Our Ref: 20026727

Planning Act 2008 – Section 88 and the Infrastructure Planning (Examination Procedure) Rules 2010 – Comments on Deadlines 8 and 9 Coastal Processes Submissions

Application by NNB Generation Company (SZC) Limited for an Order Granting Development Consent for the Sizewell C Project

Simon Barlow
Project Manager
Sizewell C Nuclear New Build
Environment Agency

Figure 13: The Beast from the East storm, 2099 Sea Level – Post-storm bed elevation for the SCDF with present-day shoreline (left) and SCDF-future shoreline position (right) cases. (BEEMS Technical Report TR545)

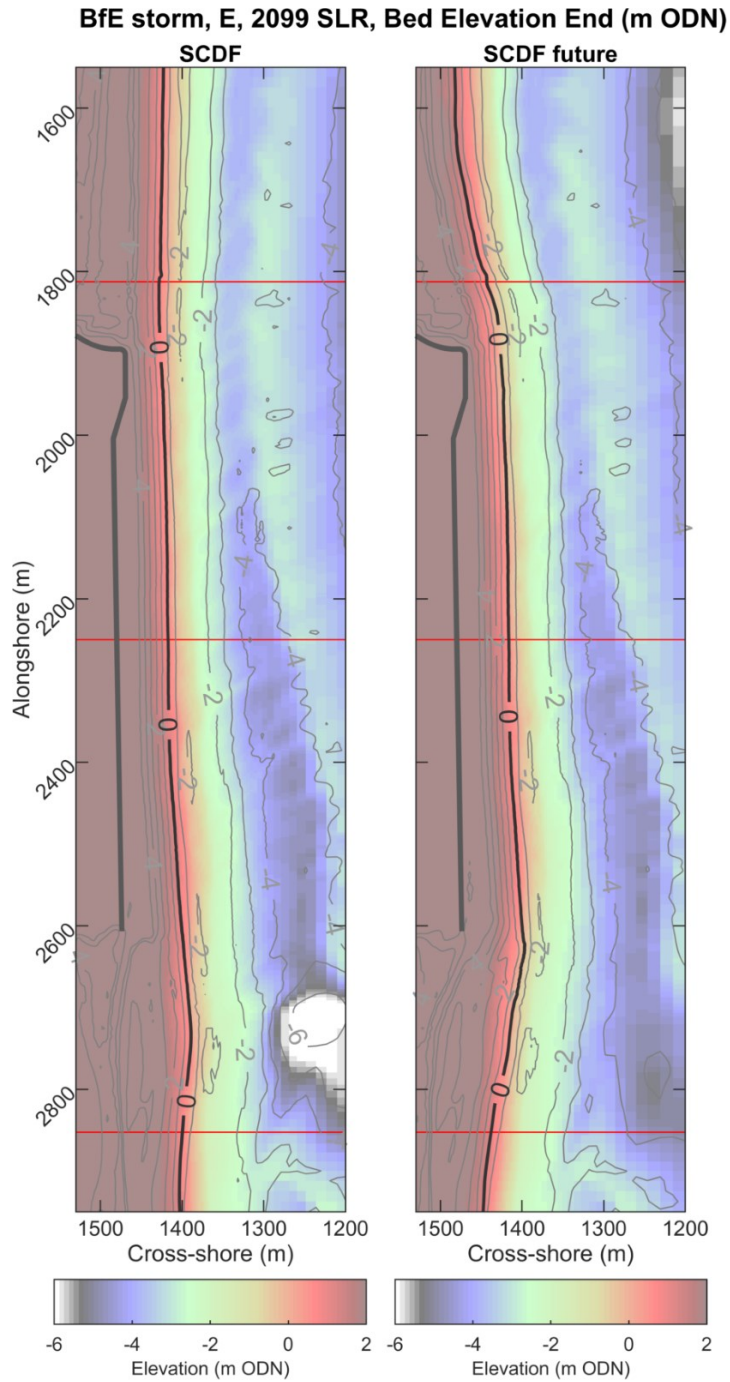
- Modelling of a more severe storm scenario than the Beast from the East sequence, which is the most extreme storm modelled and which equates to a 1 in 107 year return period for cumulative wave energy.
- Further analysis of the risk posed by two or more severe events occurring sequentially and without a safe operating window in between for delivery of mitigation measures such as beach renourishment. We note for example that no modelling has

been provided which utilises the eroded beach output of a previous model run, and would therefore simulate sequential storms without mitigation.
